DECISION DELEGATED TO HEAD OF PLANNING

Application No: H08-0890-23 **Applicant:** John Grant (Donington)
Pen. Scheme

Proposal: Residential Development - Erection of Dwelling

Location: Between 31 & 35 Westhorpe Road Gosberton Spalding

BLOCK PLAN - PROPOSED 1:200

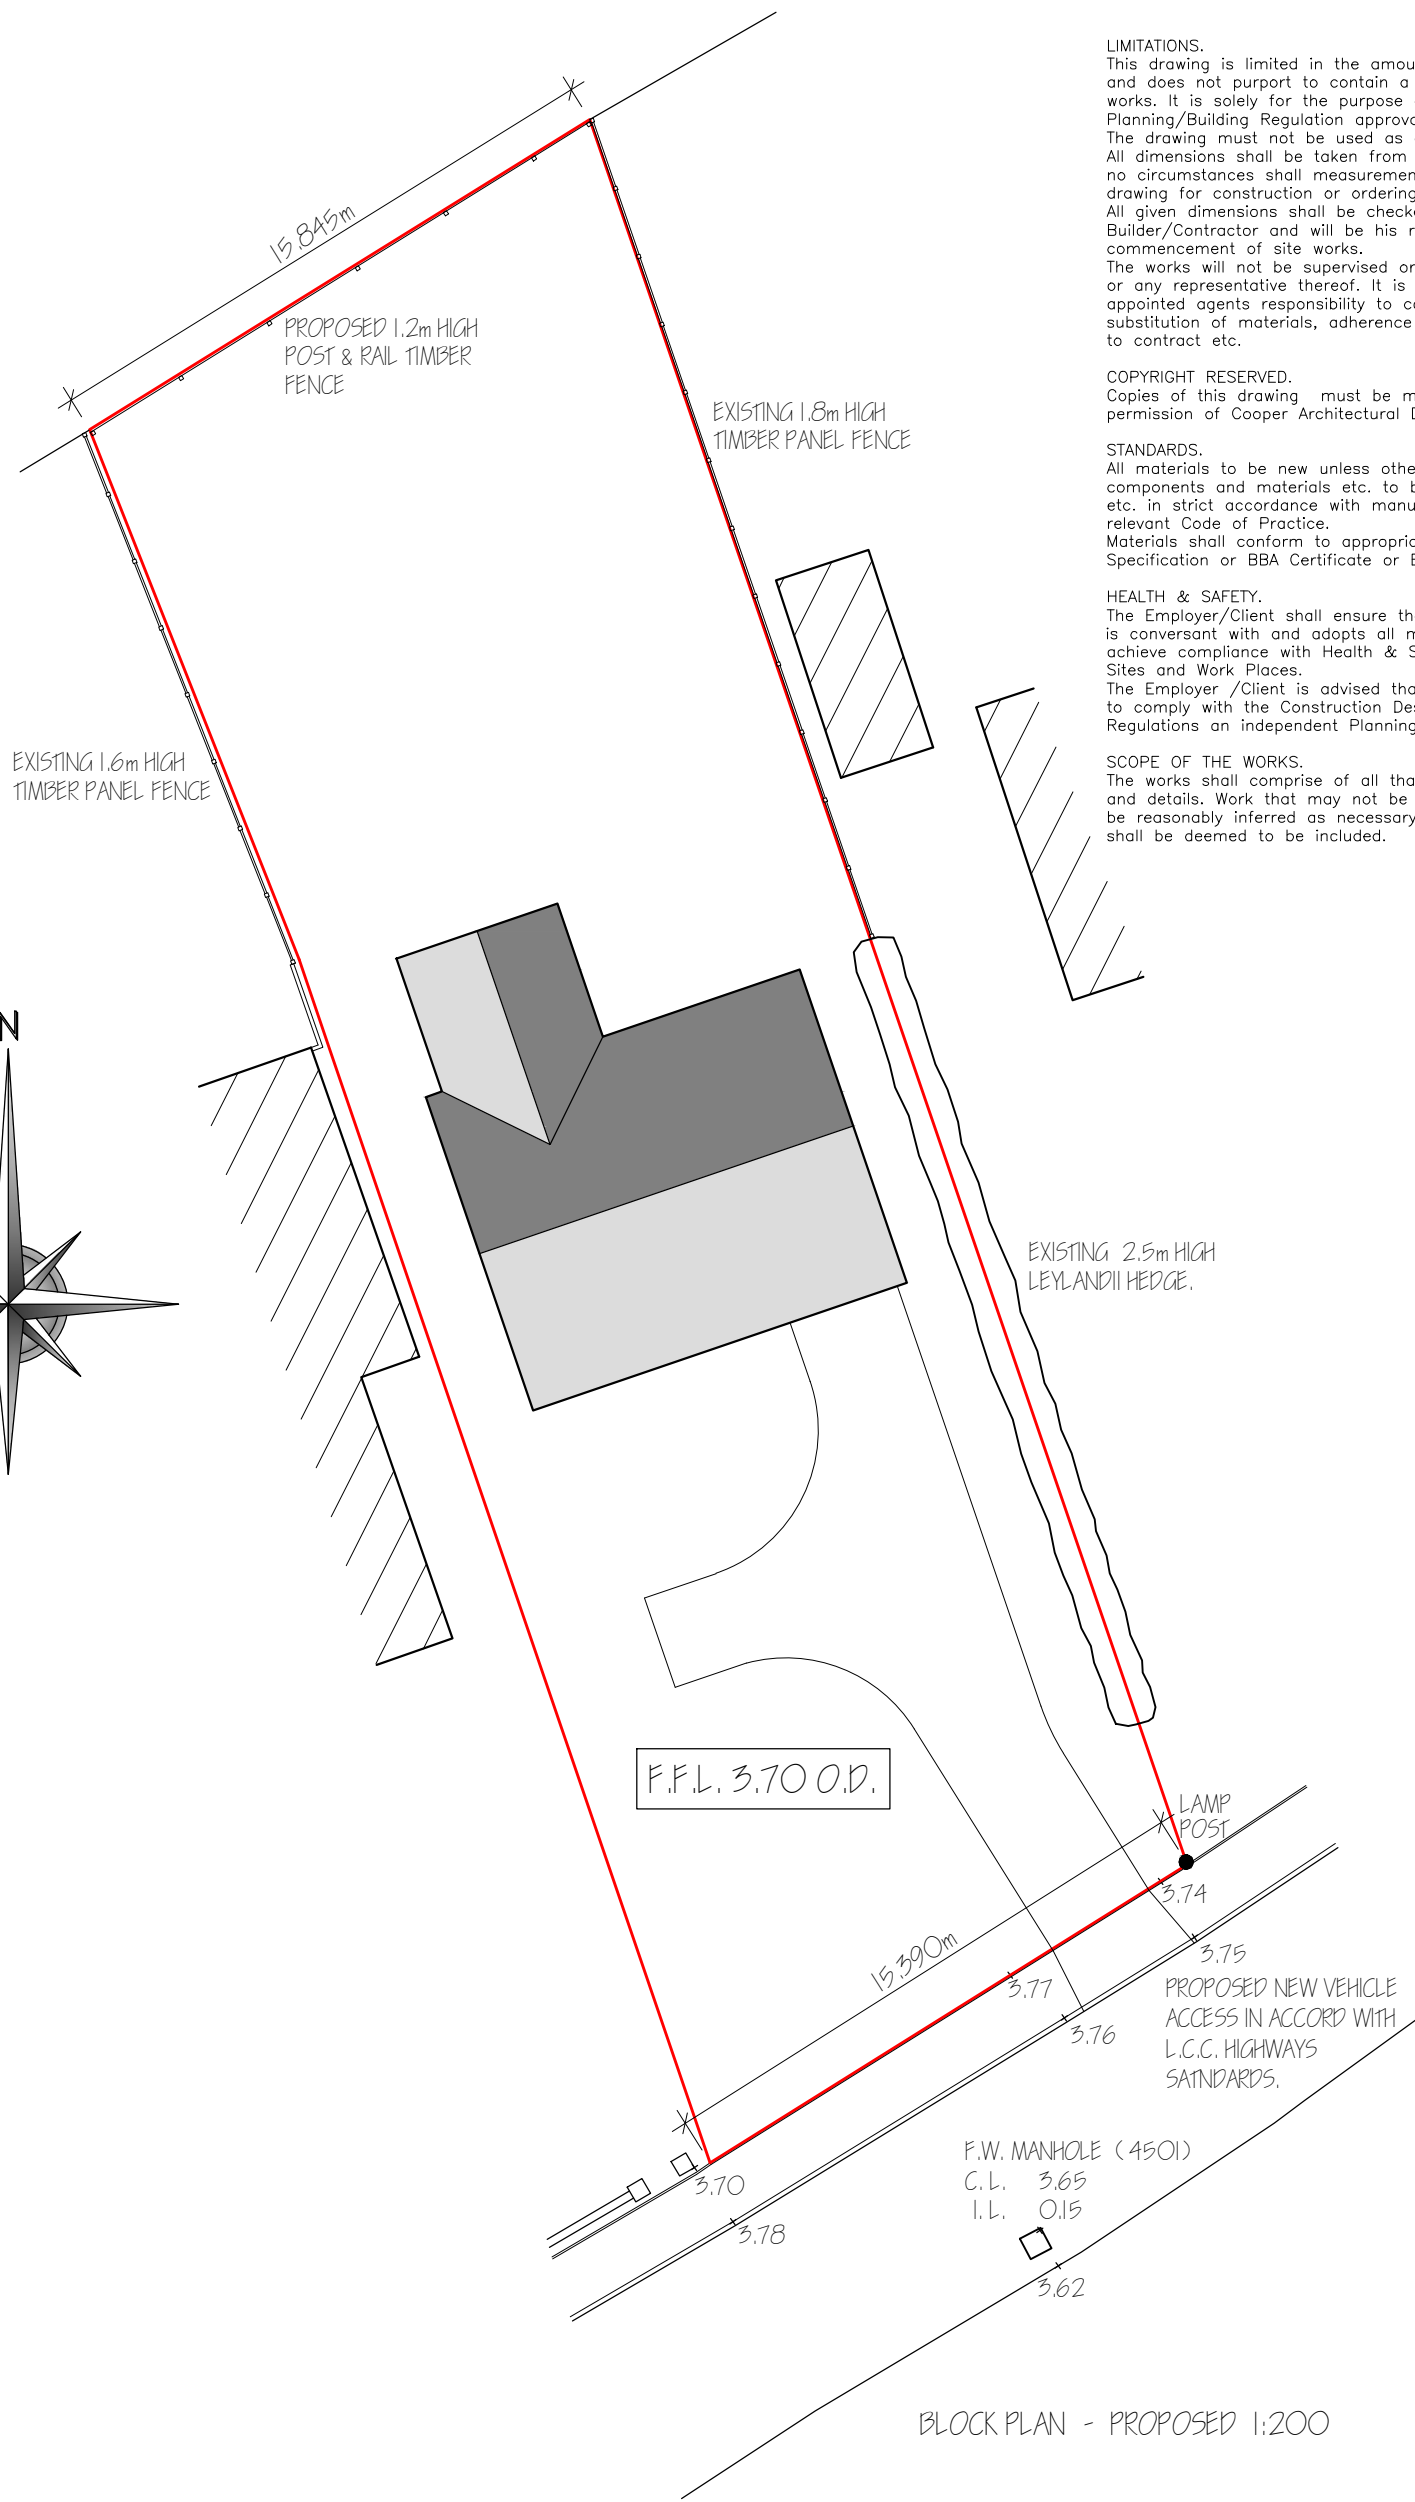
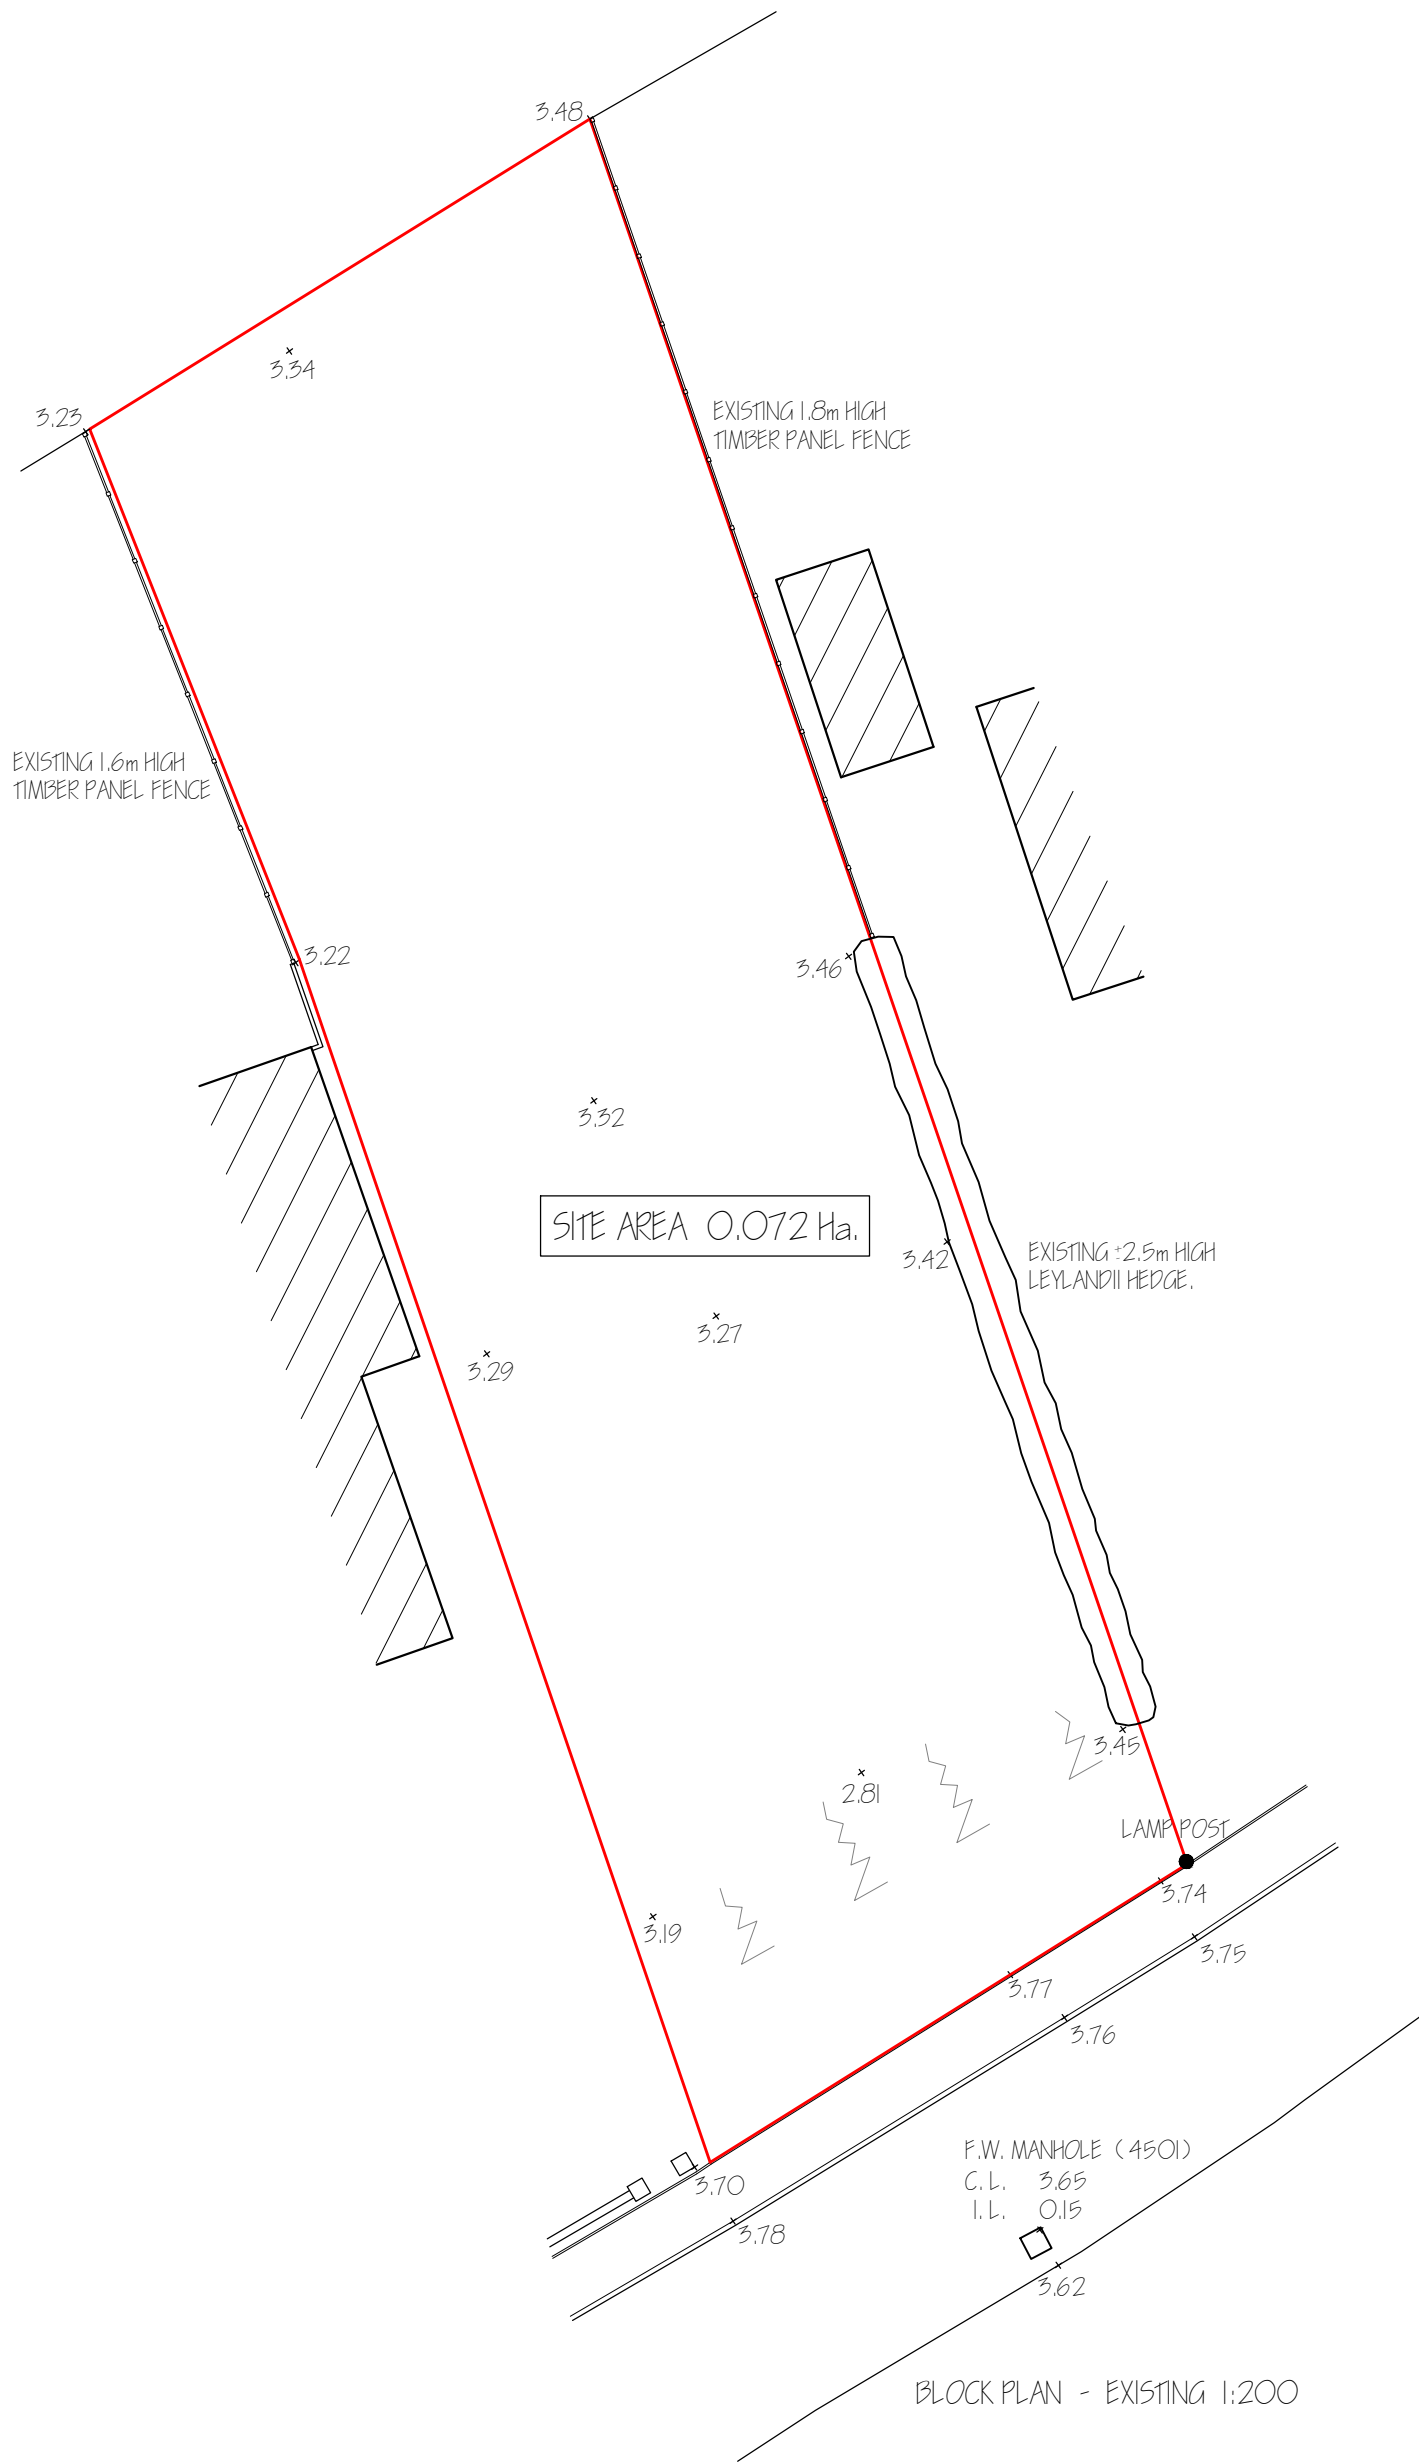
Canopy and Root Protection Area (BS 5837:2012) reaches into the eastern frontage of the plot. Before layout finalised Root Protection Area must be calculated and respected.

Layout of dwelling/driveway (and garage if one) must be designed to cause minimum conflict with preserved tree. Suggest that the driveway and any underground services to be laid, to be on the opposite side of the plot to the tree.

The access for the driveway is located adjacent to the eastern boundary. The driveway has a turning head to allow vehicles to exit the site in a forward gear. A 1.2 metre high post and rail fence is proposed for the rear boundary to the north. An existing 1.6 metre high timber panel fence serves the rear garden of 35 Westhorpe Road with no further boundary treatment along the western boundary. No boundary treatment is proposed for the southern frontage boundary. The existing 2.5 metre high leylandii hedge on the eastern boundary is to be retained, with the existing 1.8 metre high timber panel fence serving the rear garden of 31 Westhorpe Road also retained. However, as this application is all matters reserved, the indicative design does not carry material planning weight when assessing this application.

The siting of the dwelling continues the line of frontage of the dwellings either side of the site which should benefit the amenity of neighbouring properties when overlooking / overshadowing impacts are considered at the reserved matters stage. The driveway layout is recommended to be moved toward the western boundary so that the root protection areas of the protected tree at 31 Westhorpe Road is minimised. The turning head will allow vehicles to exit the site in a forward gear.

As this application is outline with all matters reserved the number of bedrooms has not been specified, however a final design for this site will need to take into account the need to provide a minimum number of off road parking spaces to address Appendix 6 of the South East Lincolnshire Local Plan. The ability to exit the site in a forward gear to minimise potential impacts on highway safety is of importance. Considerations must be made with regard to construction of a driveway within the root protection area of the preserved tree to the east of the site boundary. The Trees & Nature Conservation Officer has recommended that the proposed driveway should be constructed toward the western boundary of the site when full details are submitted as the reserved matters stage.
